Subject: ra 2024/91383 at location St Johns Church, Jackroyd Lane, Newsome, Huddersfield, HD4 6QU

Please see this as additional commentary (solely concerning the BNG element), following my commentary on 13th October.

BNG

## **Appendix 2. Proposed Habitat Survey Plan**

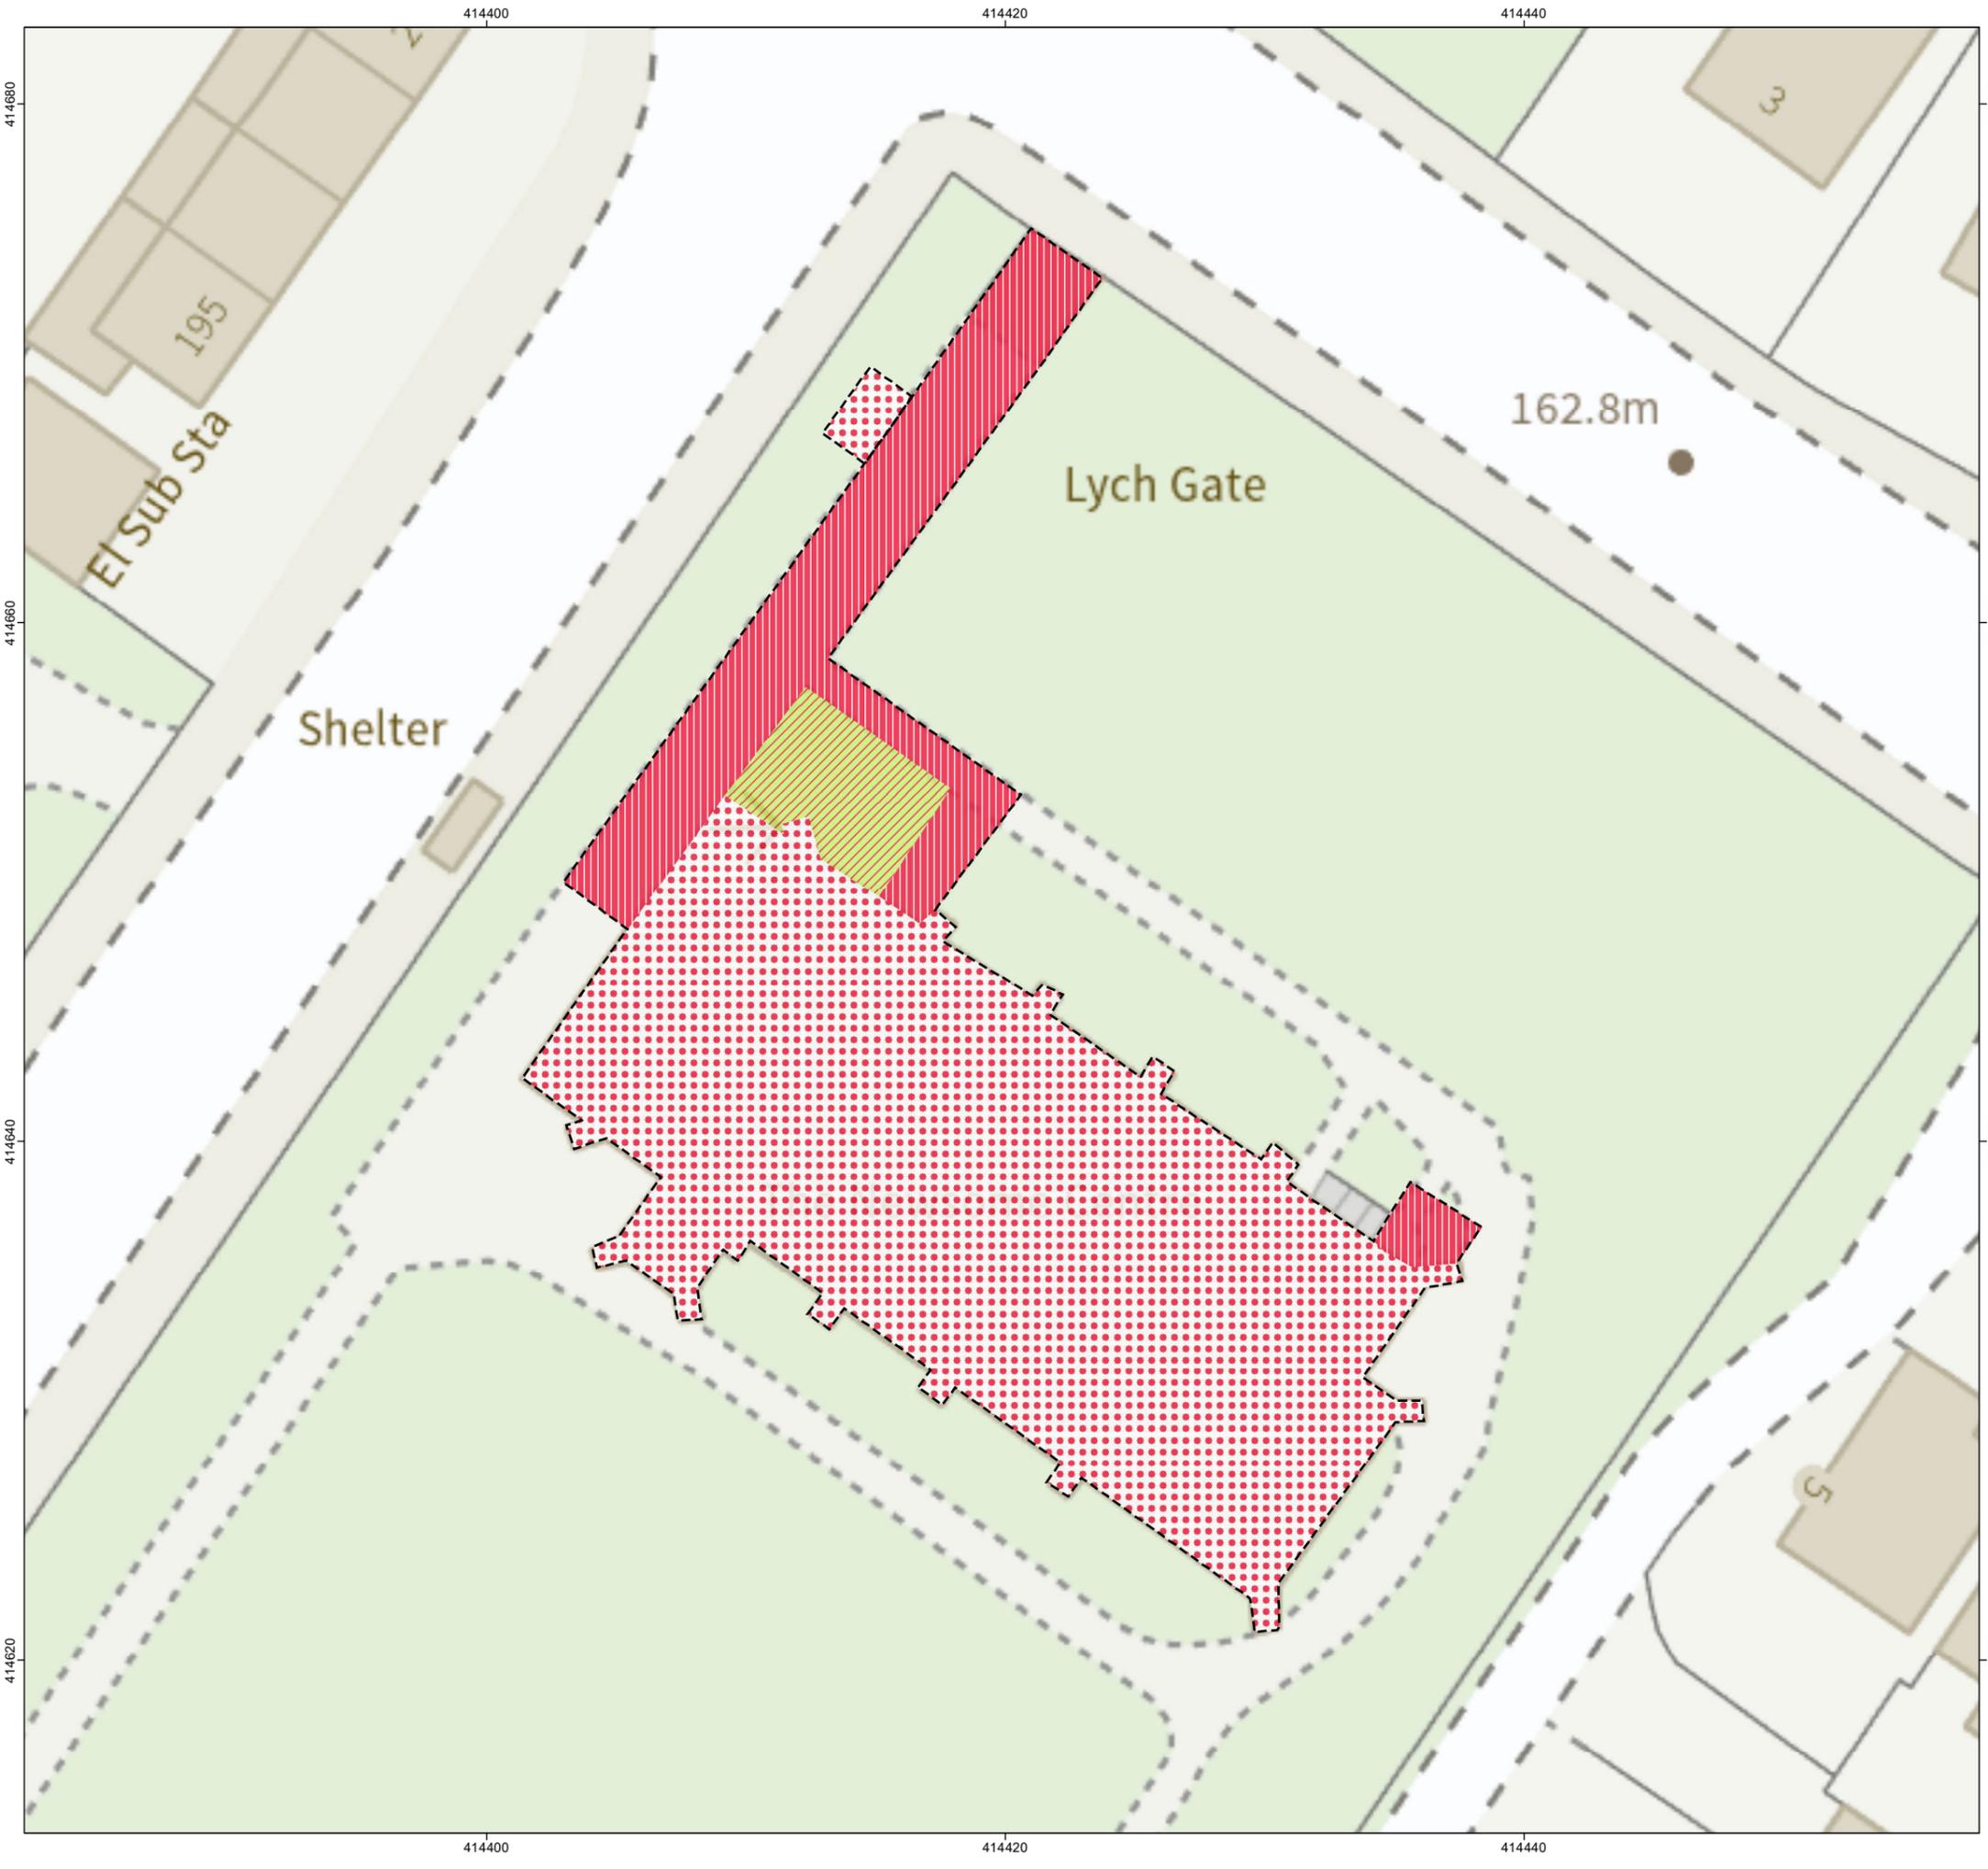
The BNG report and metric show a net loss of 0.33 habitat units. This includes v low to medium distinctiveness habitats.

0.36 habitat units are required in order to meet the statutory 10% BNG requirements.

- A plan that follows the UK Habitat Classification showing the spatial locations of the habitats represented in the enhancement and/or creation tabs of the biodiversity metric (i.e. the target habitats).
- The georeferenced spatial data used to create both above plans (in either .shp or .gpkg format) and written permission to share this data with West Yorkshire Records Centre.
- A 30-year Habitat Management and Monitoring Plan (HMMP)
